# A R C H I T E C T Y P E

May 22, 2015

RE: The Science Center  
68 Maine Wharf  
Portland, Maine

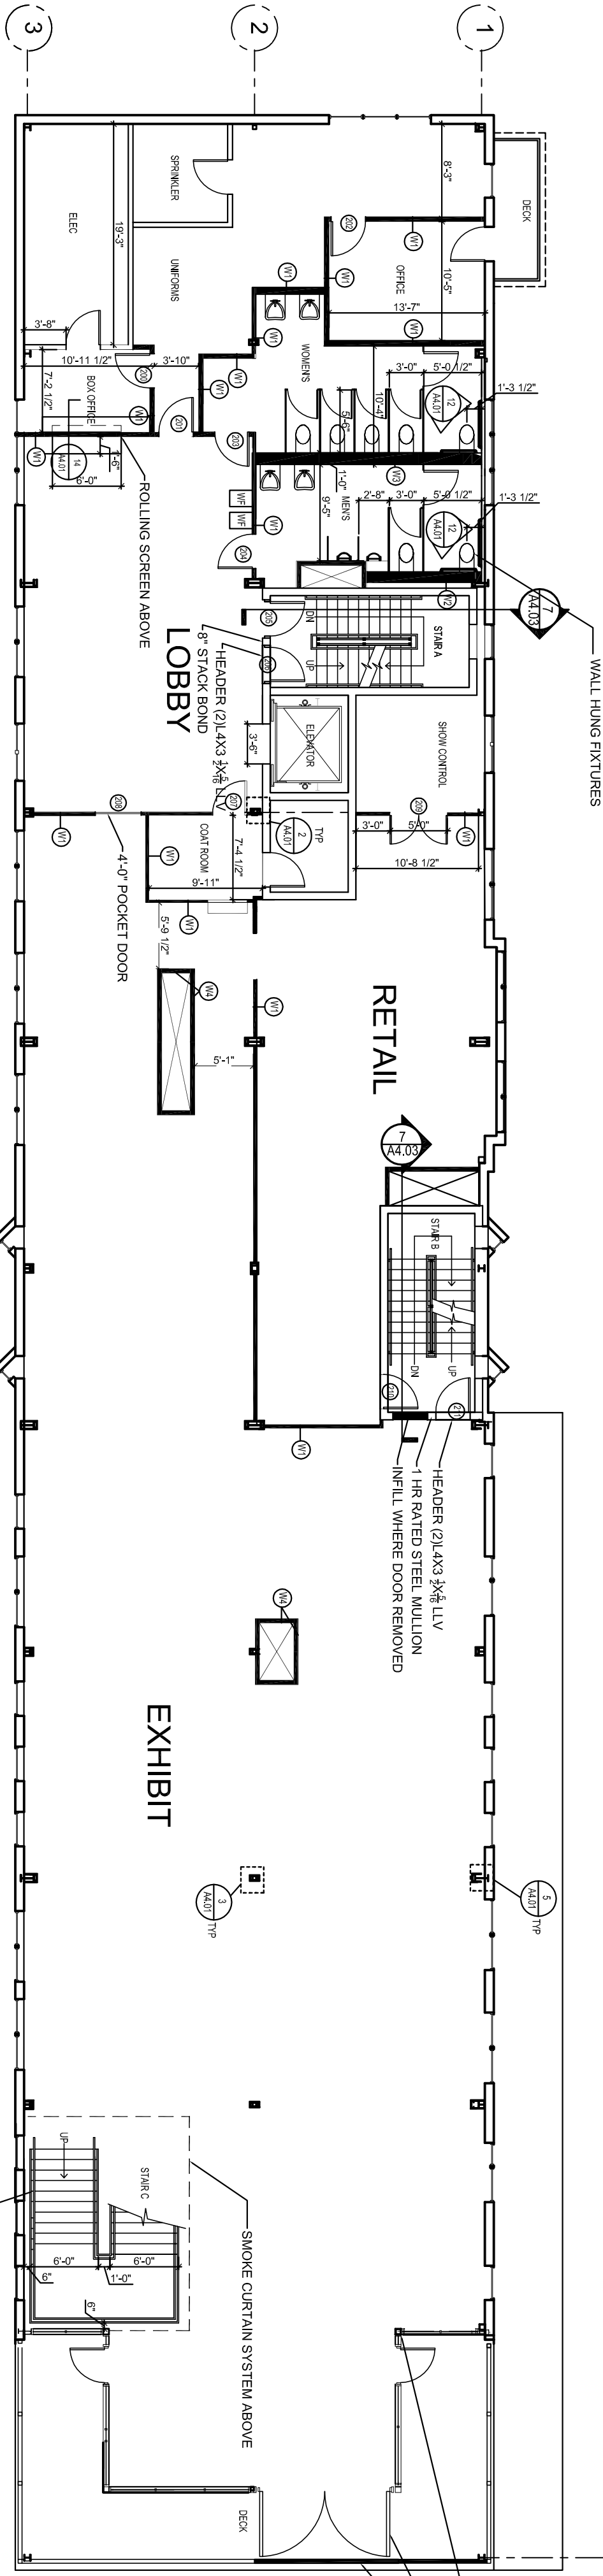
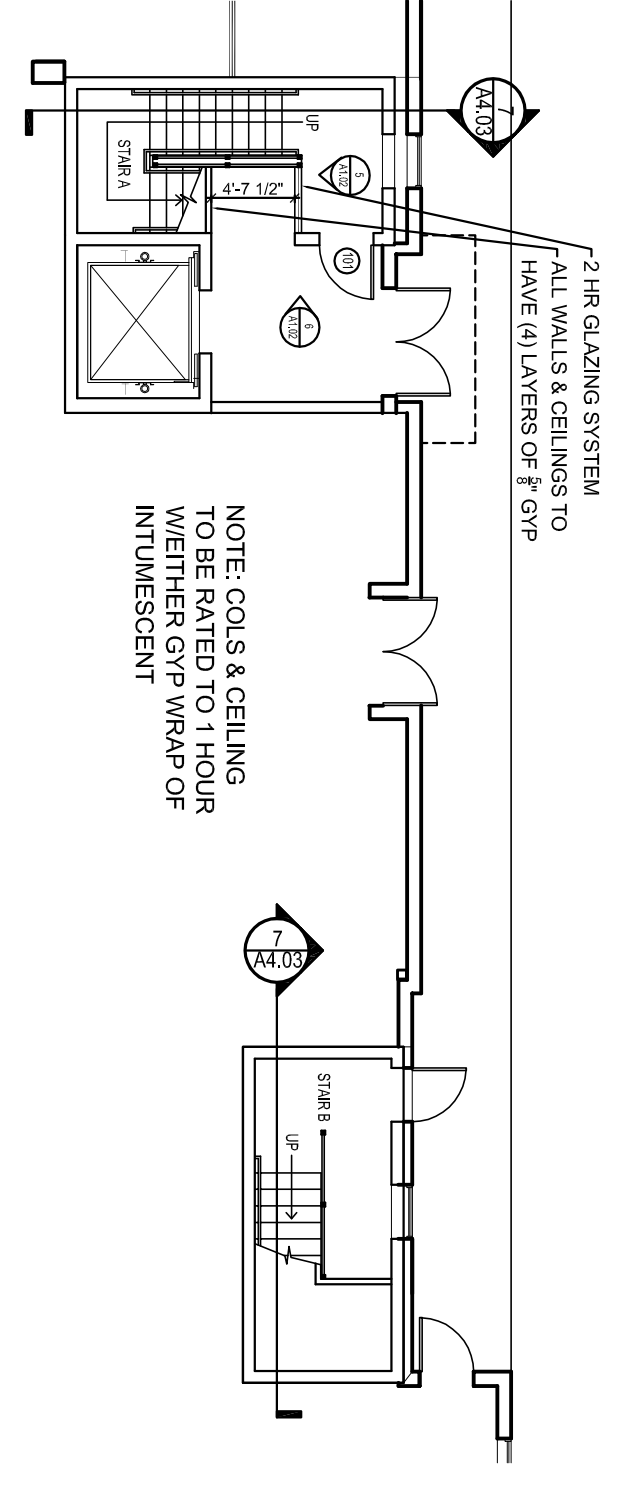
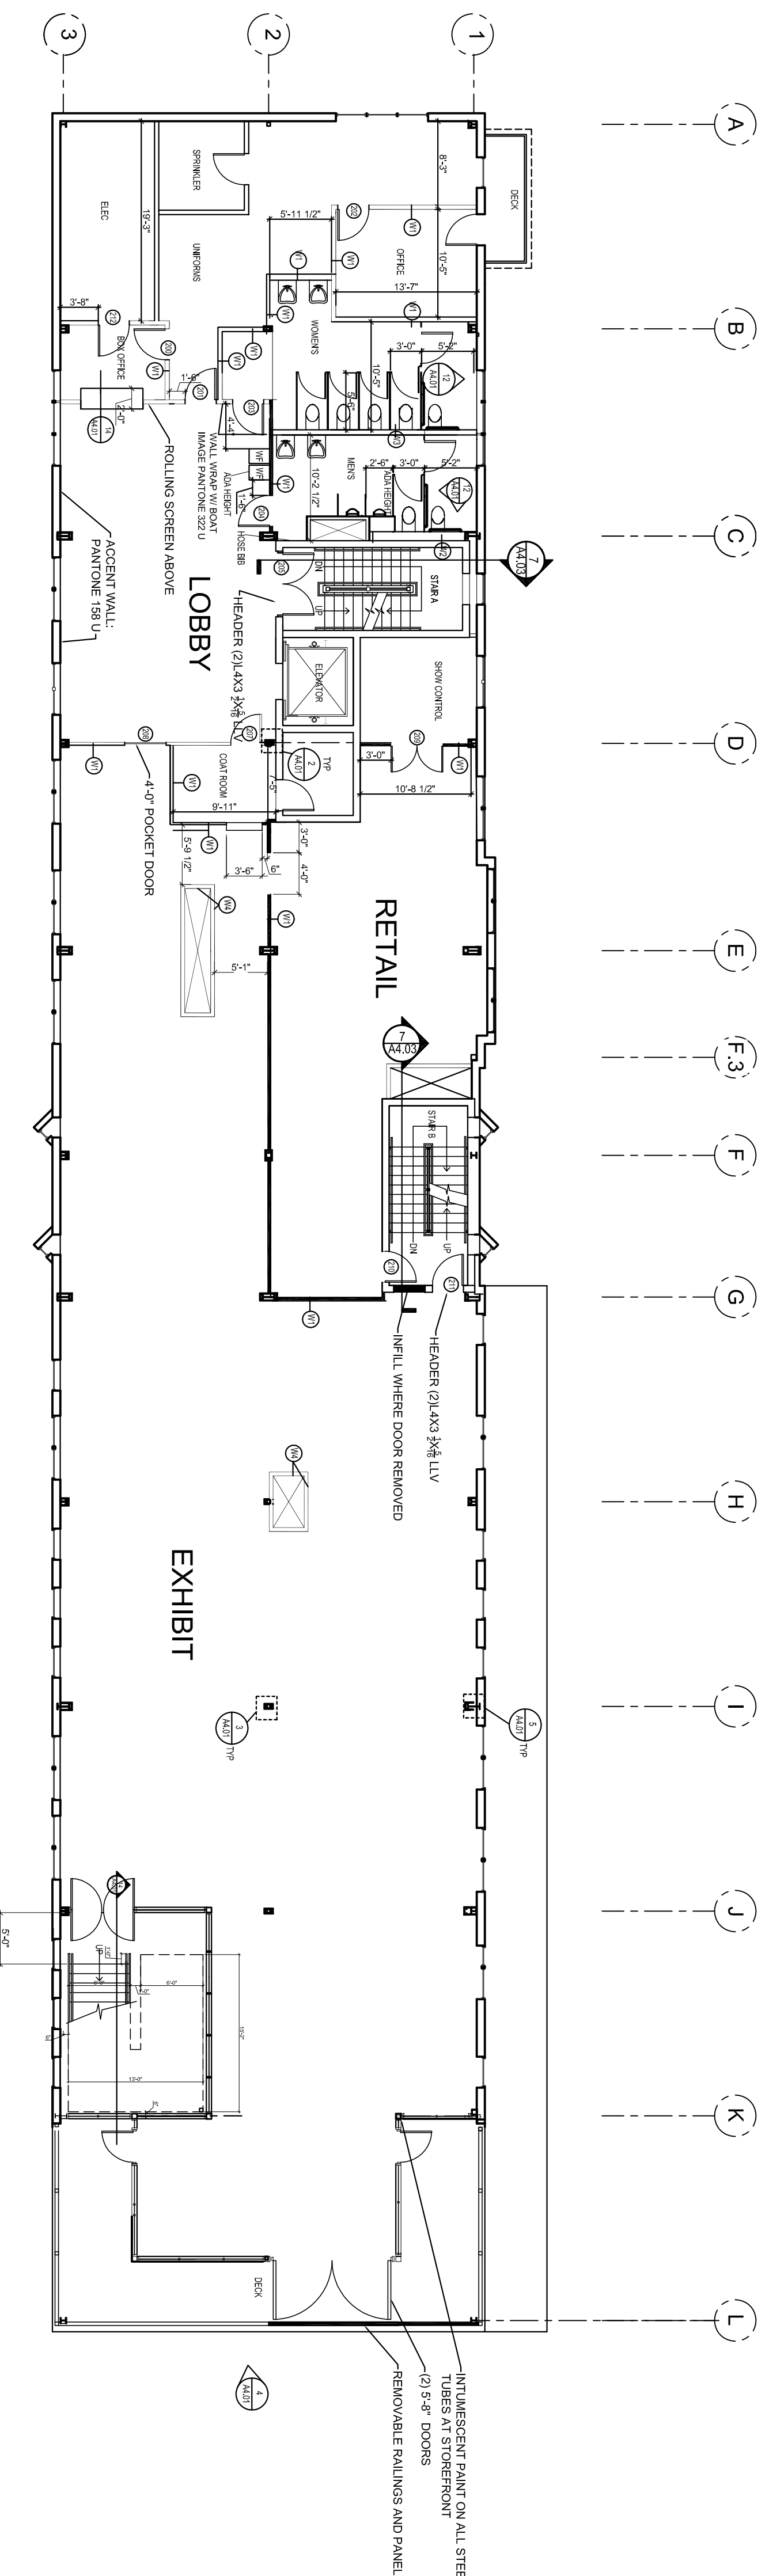
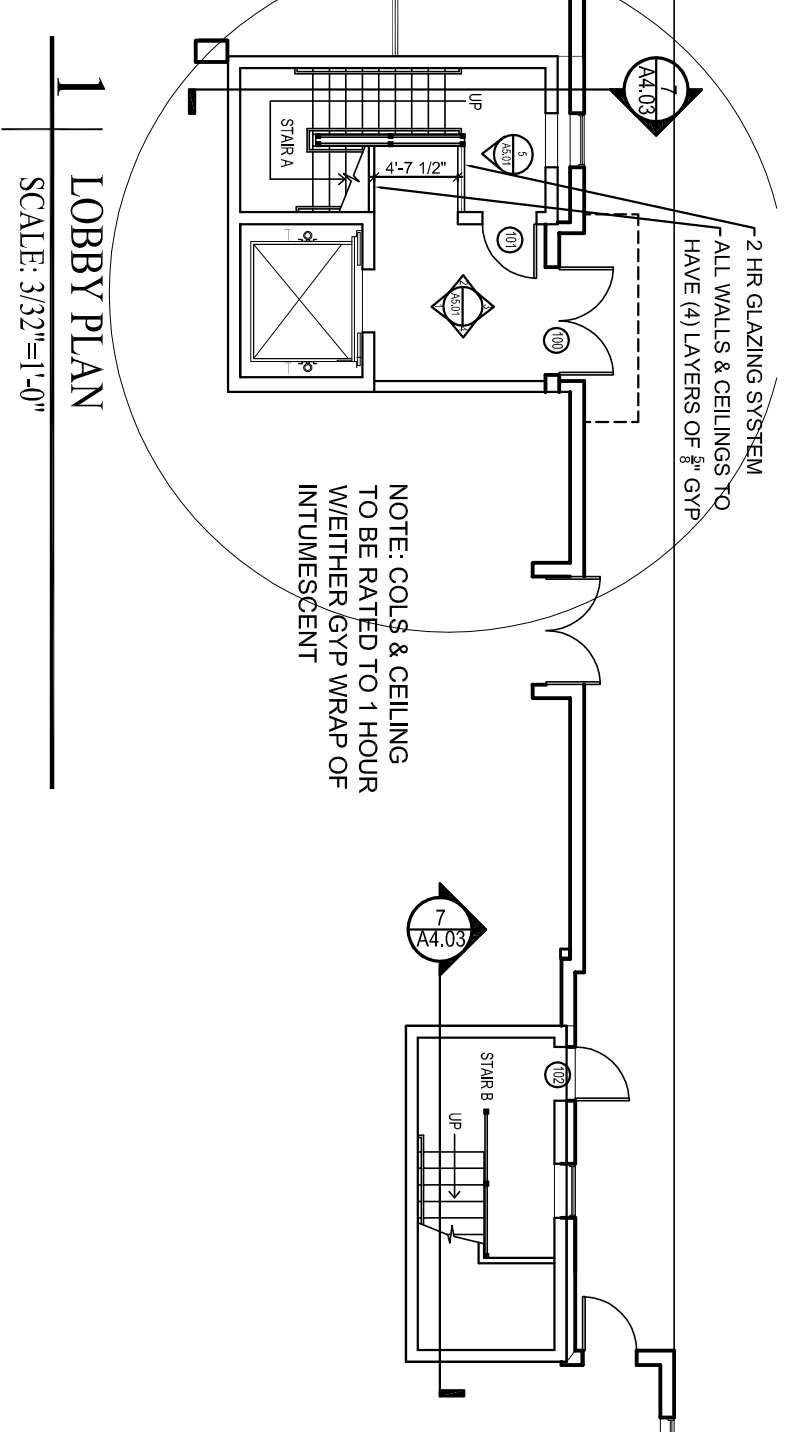
In the course of our own internal review of the project Mark Cummings of Fire Risk Management noticed that the common path of travel from the south end (or right side of the floor plan) to the nearest exit stair exceeds the allowable distance for an assembly occupancy. I have attached Marks suggestion to incorporate our proposed convenience stair into our egress along with our revised drawings.
